From: [REDACTED]@iarch.co>
Sent: 10 April 2026 06:29
To: Norwich to Tilbury
Cc: [REDACTED]; N-T Surveys
Subject: Lynton, Lower Dunton Road - IPR Numbers [REDACTED] and [REDACTED]
Attachments: Lynton NG alternatives submission 250226.pdf

Lynton, Lower Dunton Road, CM13 3BP

Representation regarding the impact of the
proposed Norwich to Tilbury electricity transmission
proposal on residential development

25th February 2026

Map showing one of several versions of National Grid's proposals

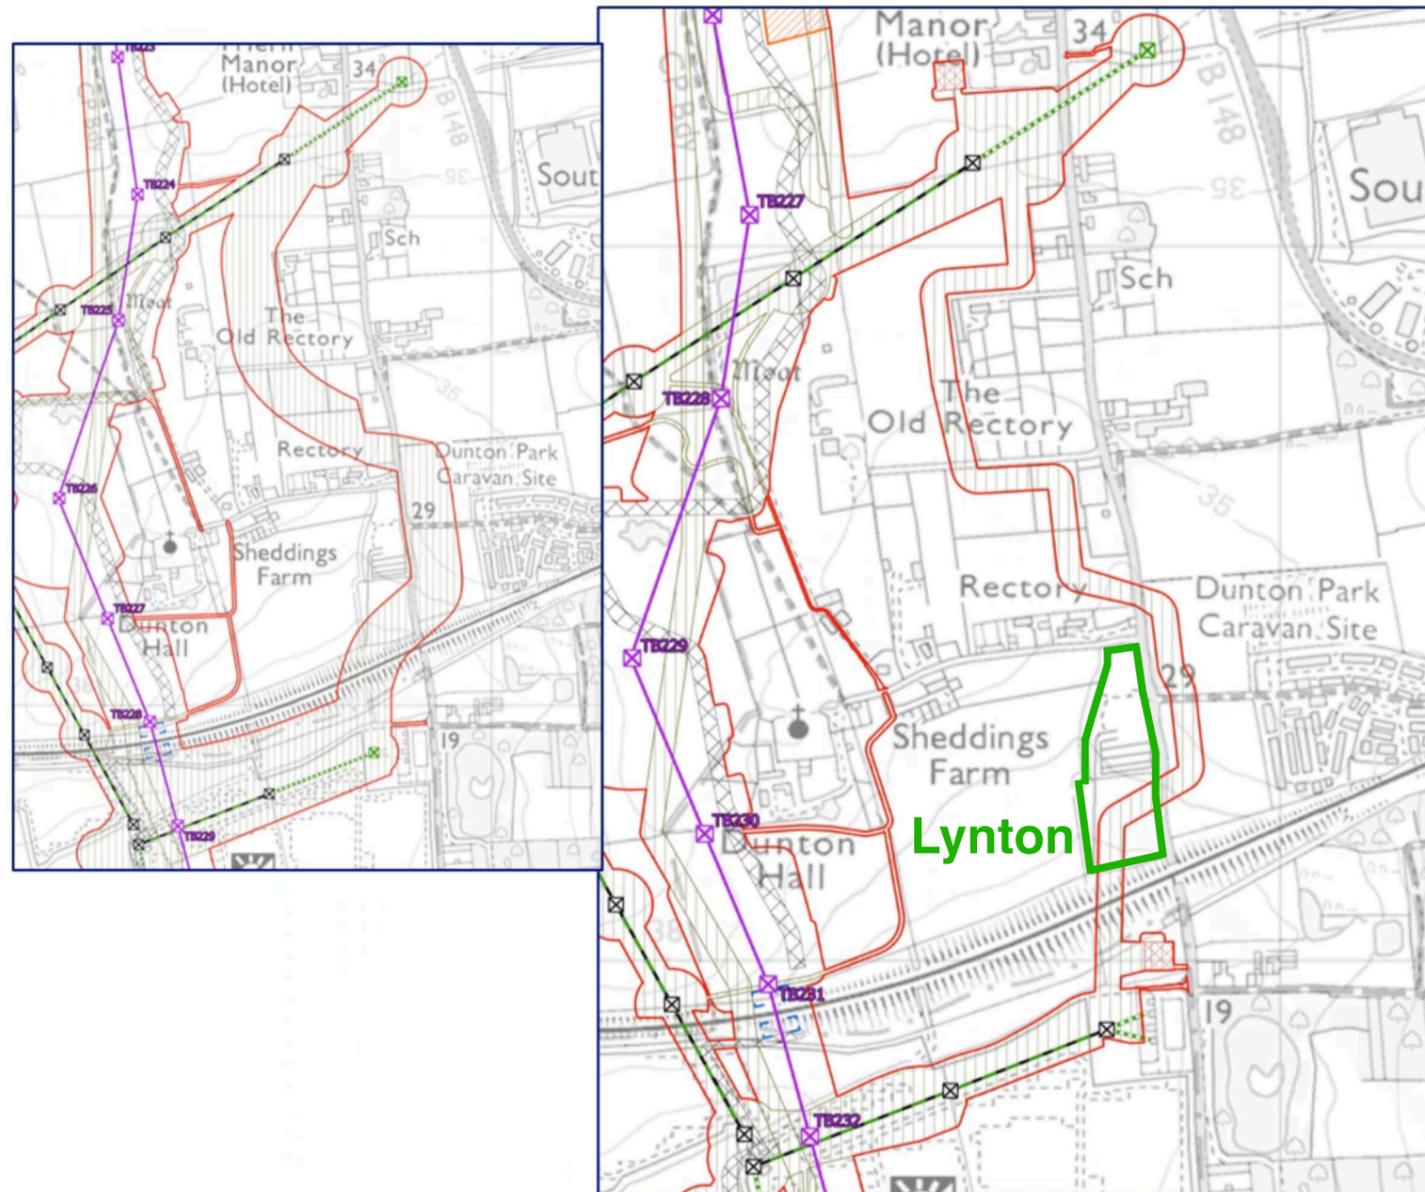
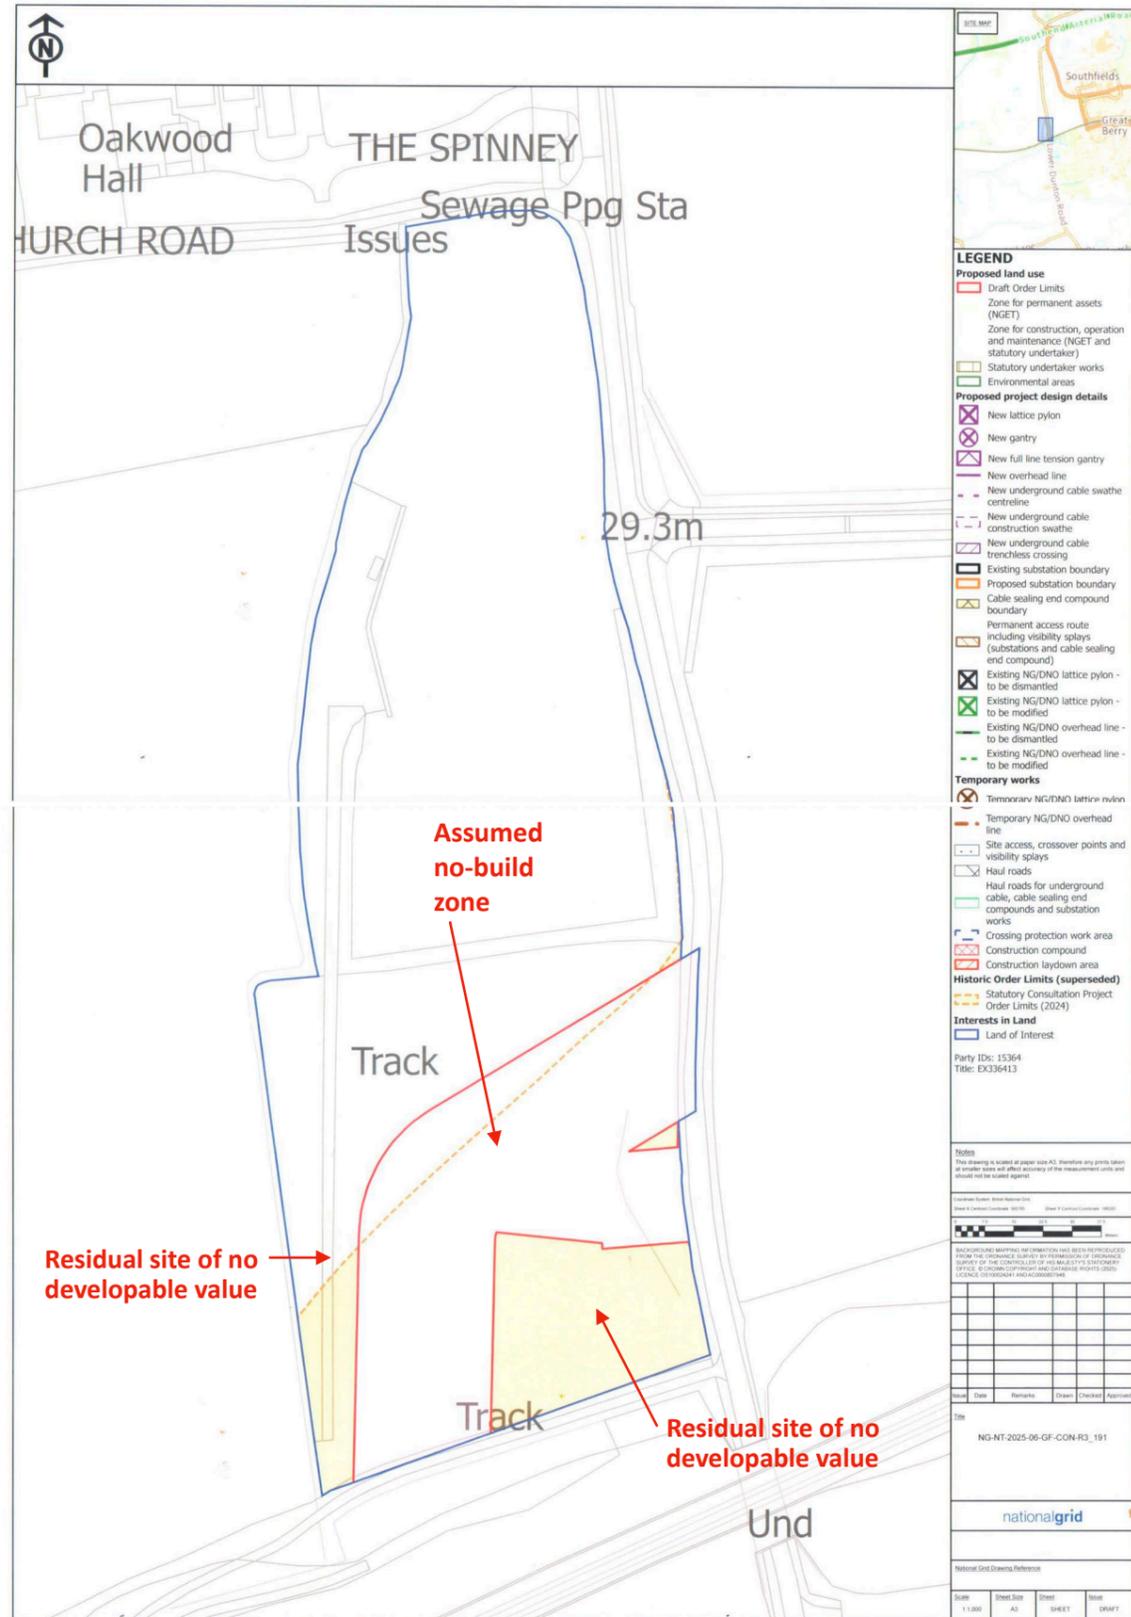
As is clear from the drawing shown on this page, the proposed electrical infrastructure has a very significant impact on the Lynton site. It is also clear that the routing of the underground cable, and its no-build zone, is quite flexible, as elsewhere on the same plan it is shown as incorporating turns in some cases exceeding 90 degrees, to align with plot boundaries and avoid impacting specific properties.

## SITE PLAN

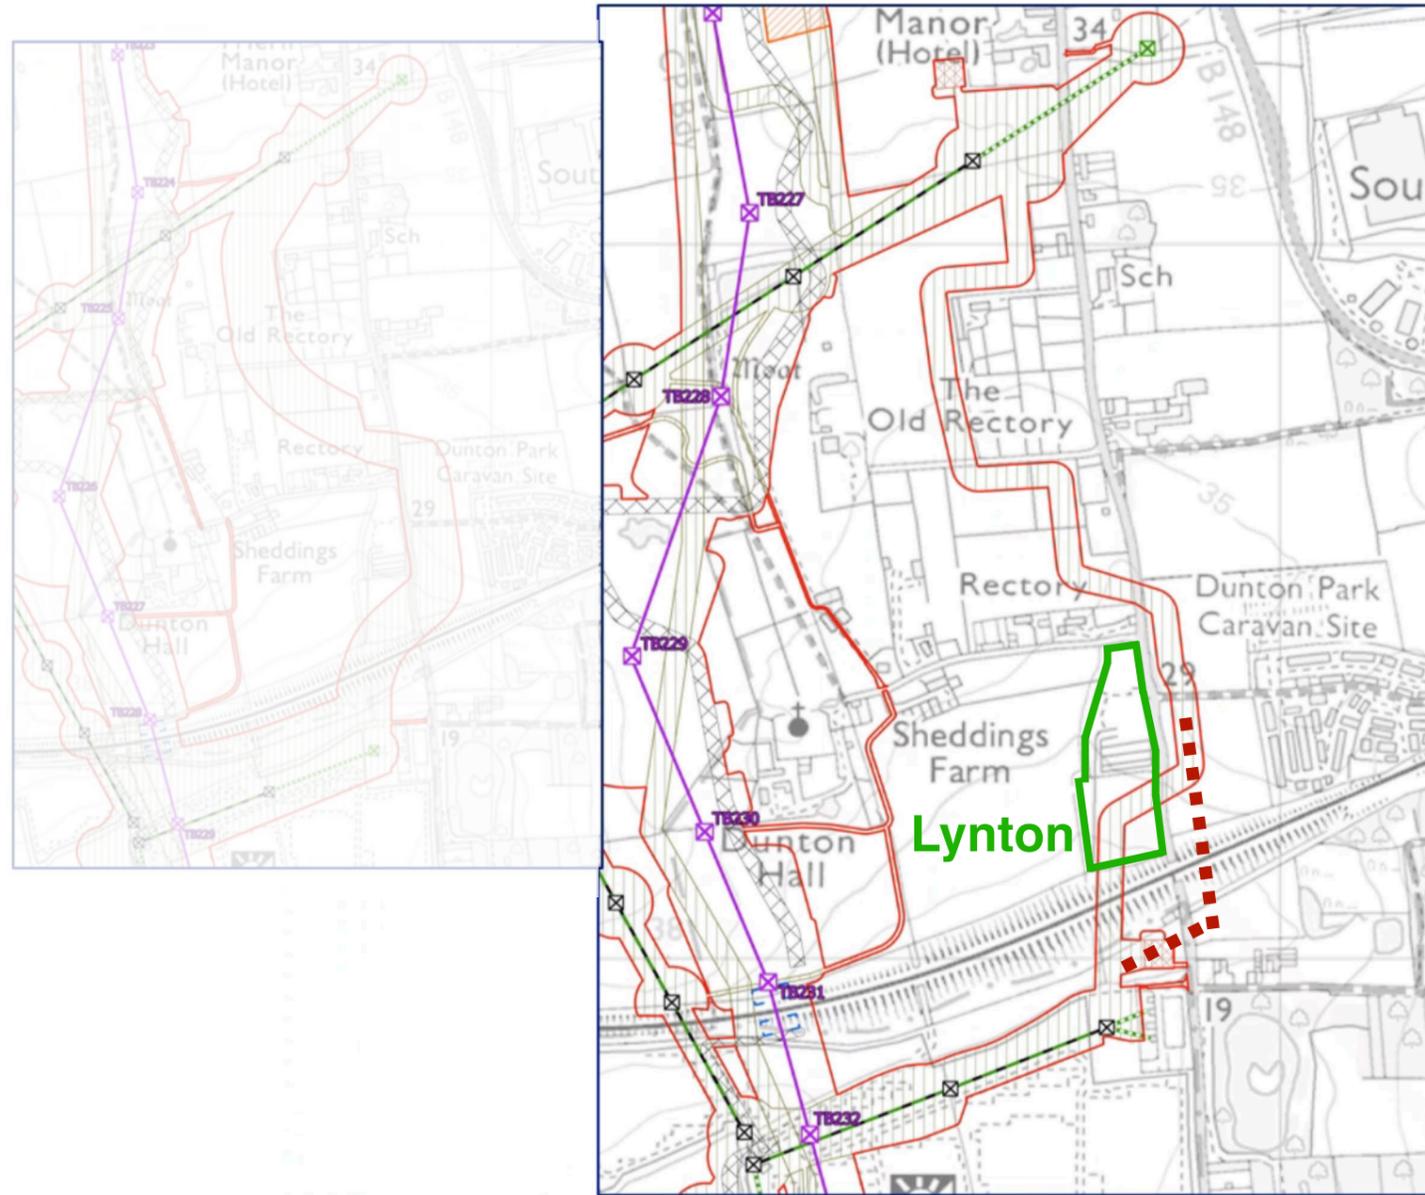
This drawing shows National Grid's proposed no-build zone overlaid on Westland Farm Developments' proposed residential development

Residual site of no developable value

## Alternative B

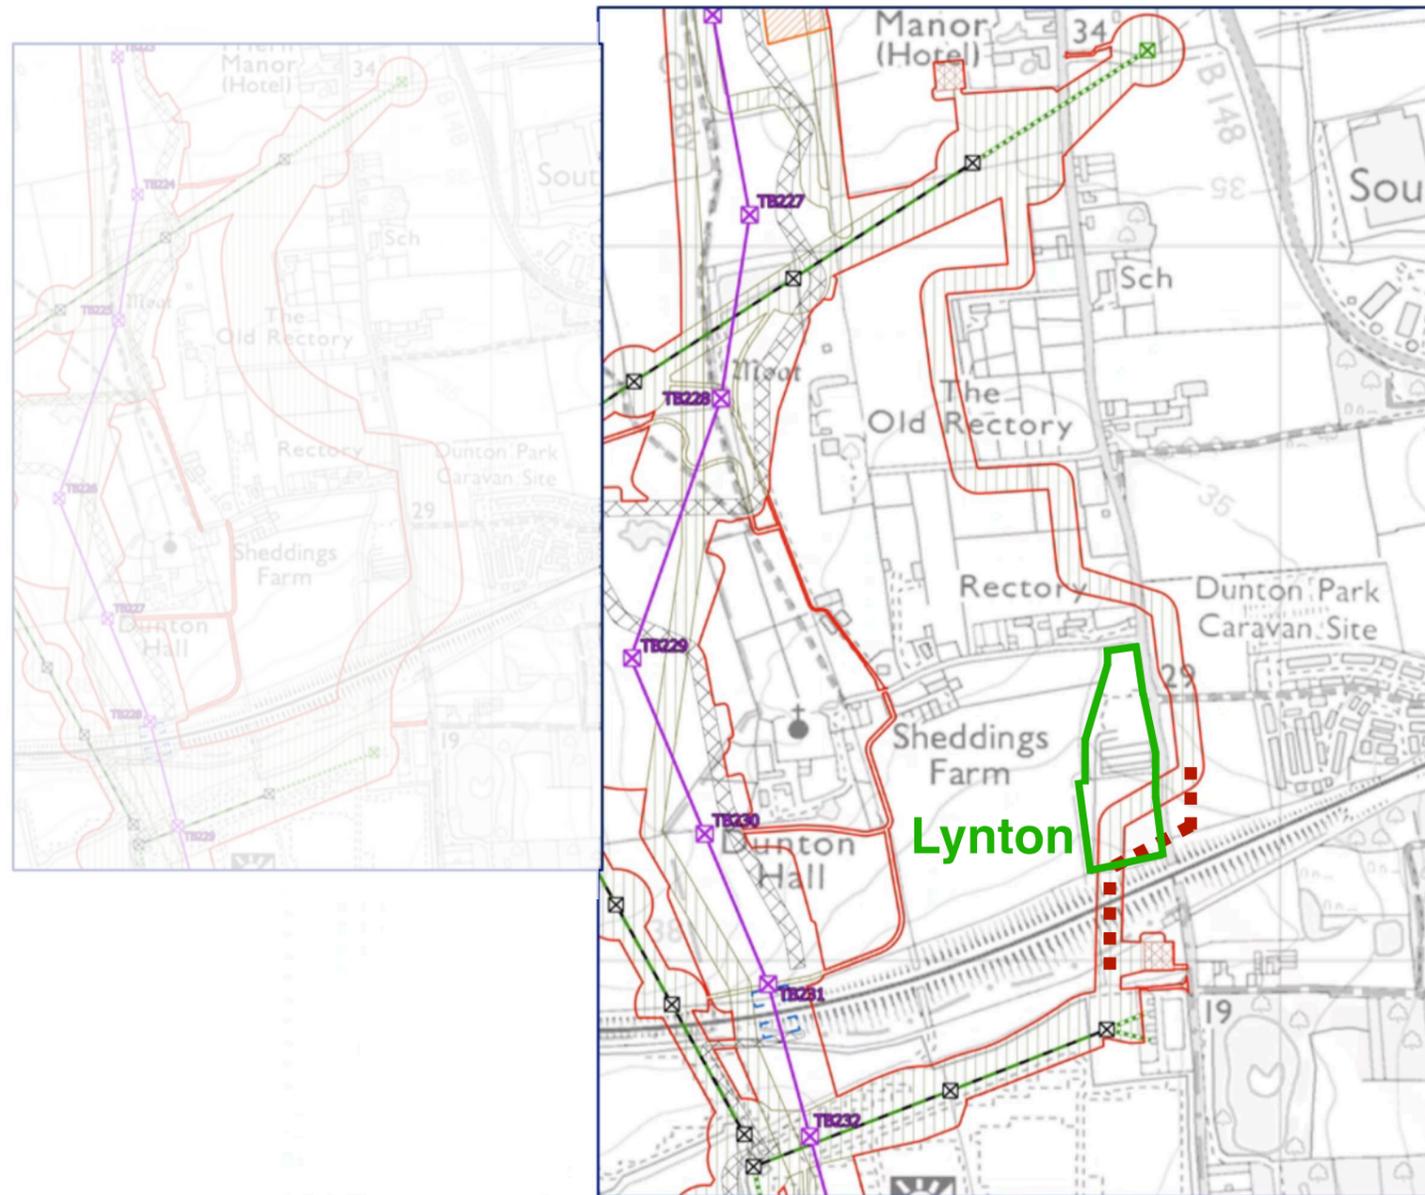
If our Alternative A is unviable for whatever reason, we would request that National Grid consider an alternative routing of the underground cable, aligned with Lynton's southern boundary, substantially within the zone adjoining the railway embankment which has a higher flood risk and is therefore of limited development value.

# Alternative C

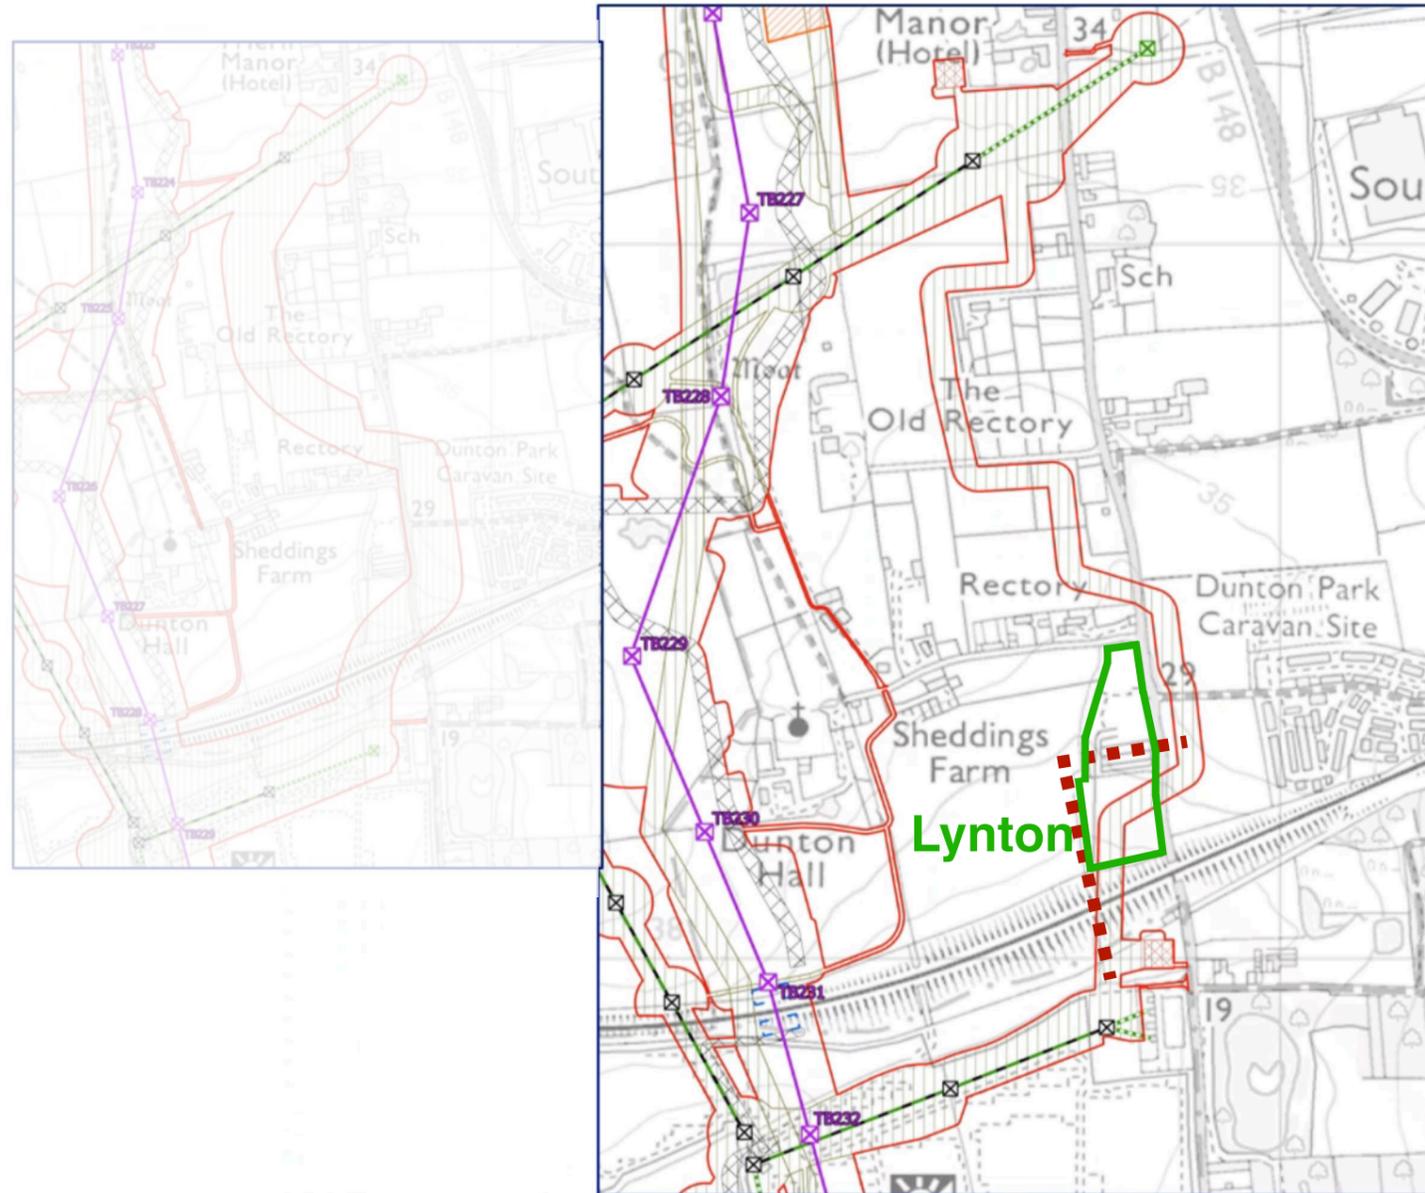
A further alternative which National Grid may consider would route the underground cable through the central part of Lynton, but align the no-build zone with an area dedicated to amenity uses, thus having very limited adverse impact on the residential development. This is shown in greater detail on the next page.
